Riverside Energy Park, Belvedere

Planning Inspectorate reference: EN010093

National Infrastructure Project Development Consent Order application - Written representation

Development Consent Order, Section 90 of Planning Act 2008

Figure 7.10 Rev 0

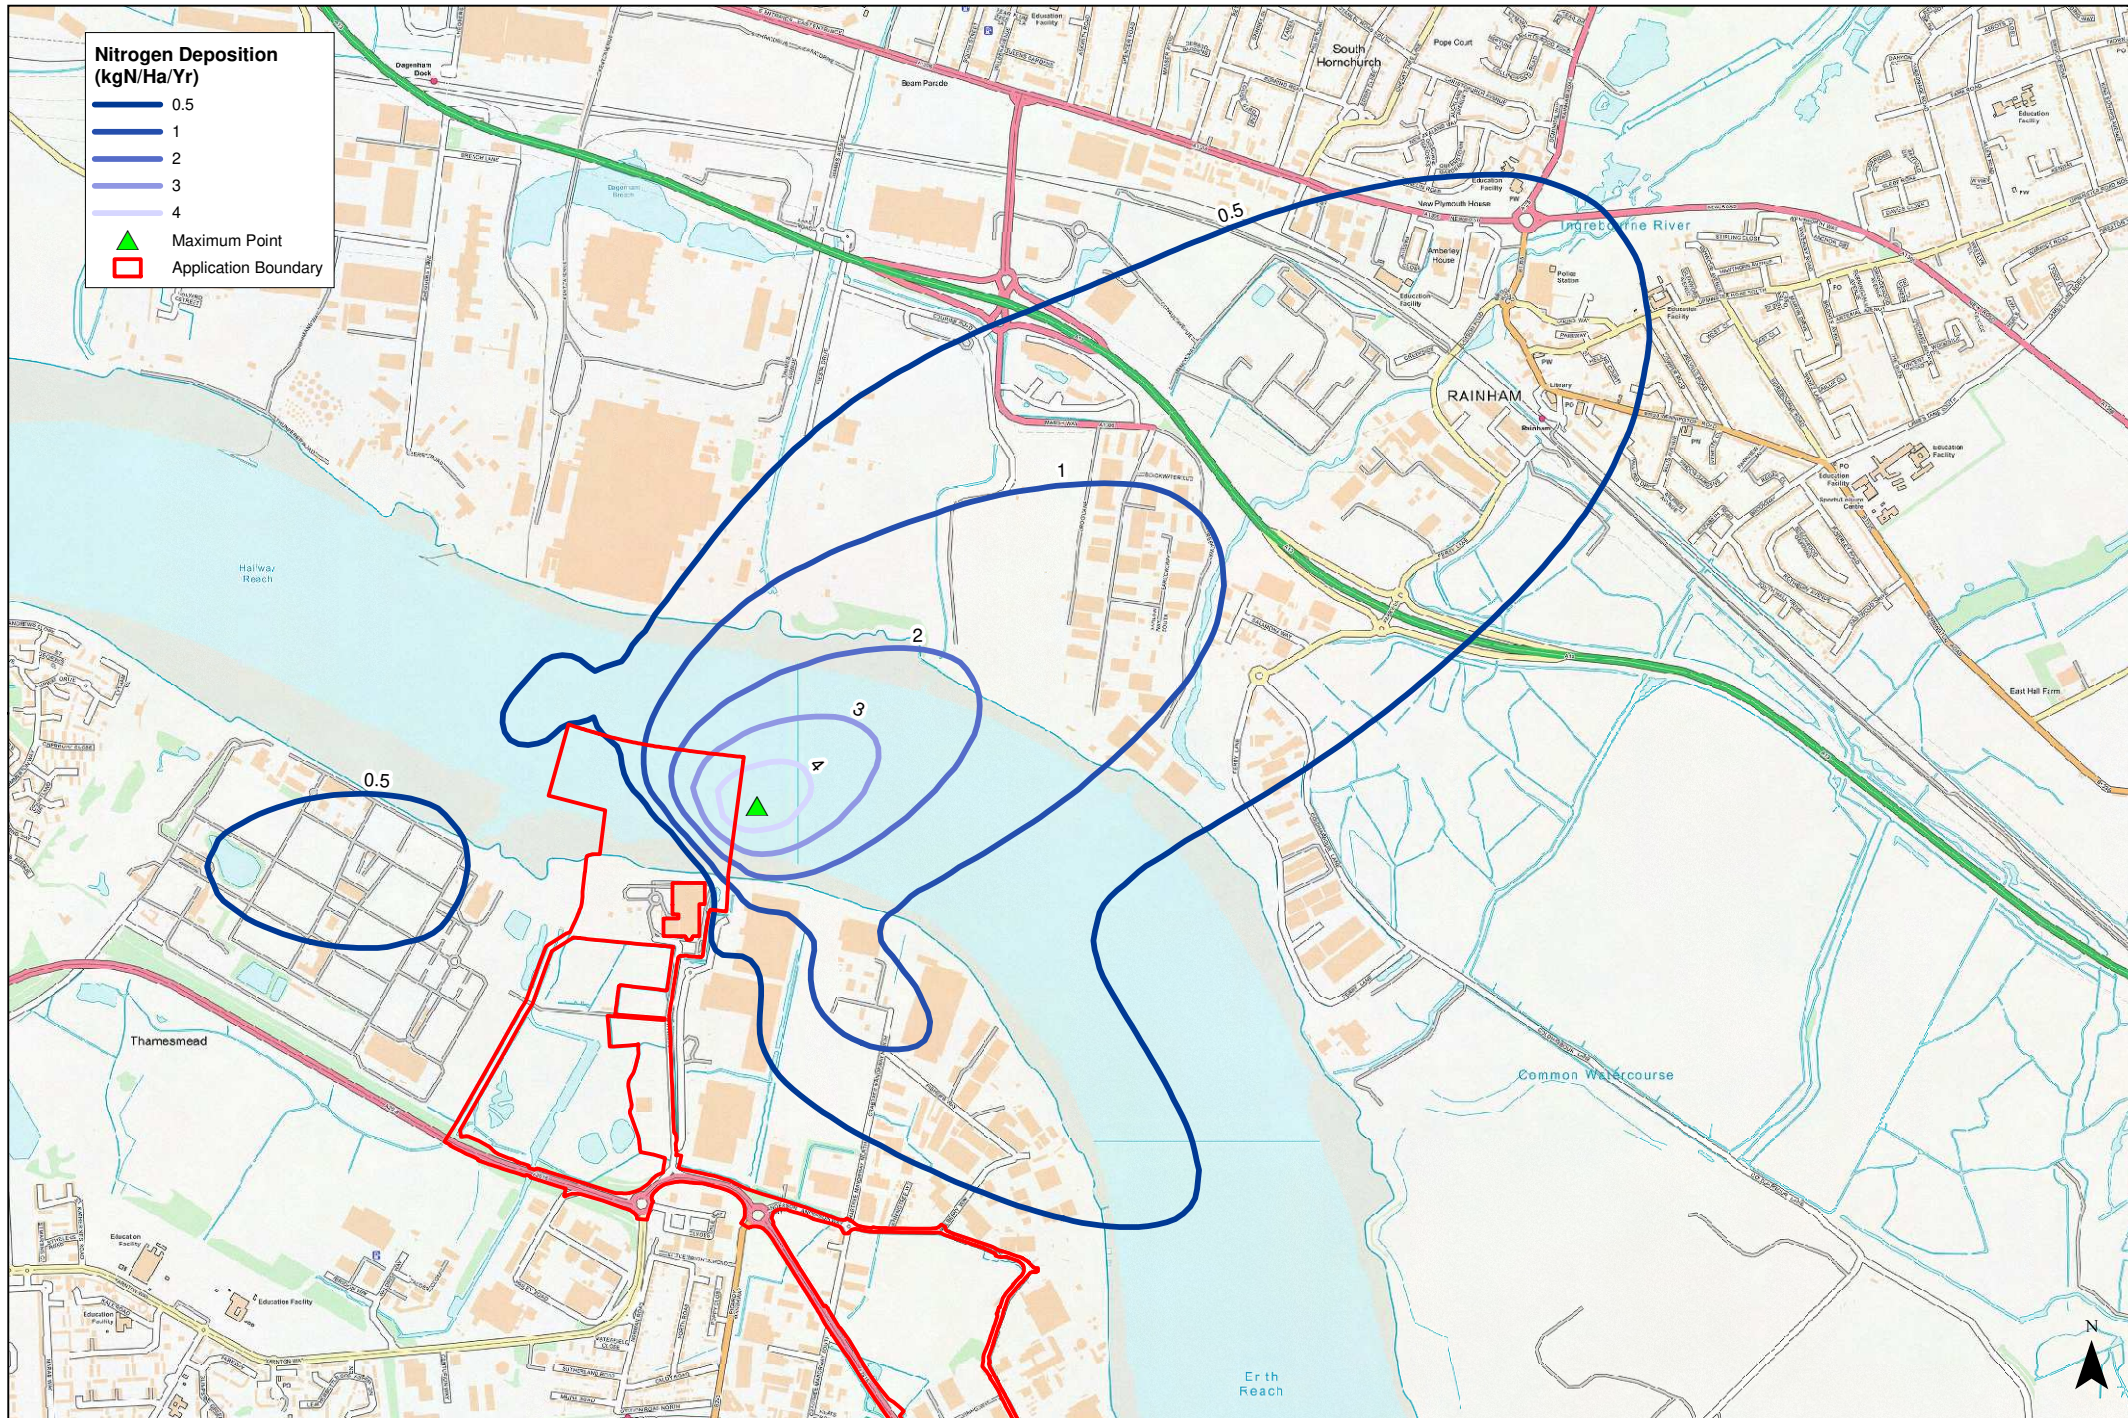
- **Air quality:** The proposed ERF will emit over 4 times as much nitrogen oxides as currently emitted from the existing RRRF and Crossness Sewage Sludge Incinerator combined. Arsenic emissions will double. The proposals are not consistent with the NPS, fail to consider adjacent Opportunity Areas and do not sufficiently assess the impact of NOx on the nearby Sites of Special Scientific Interest (SSSI) or AQMAs.
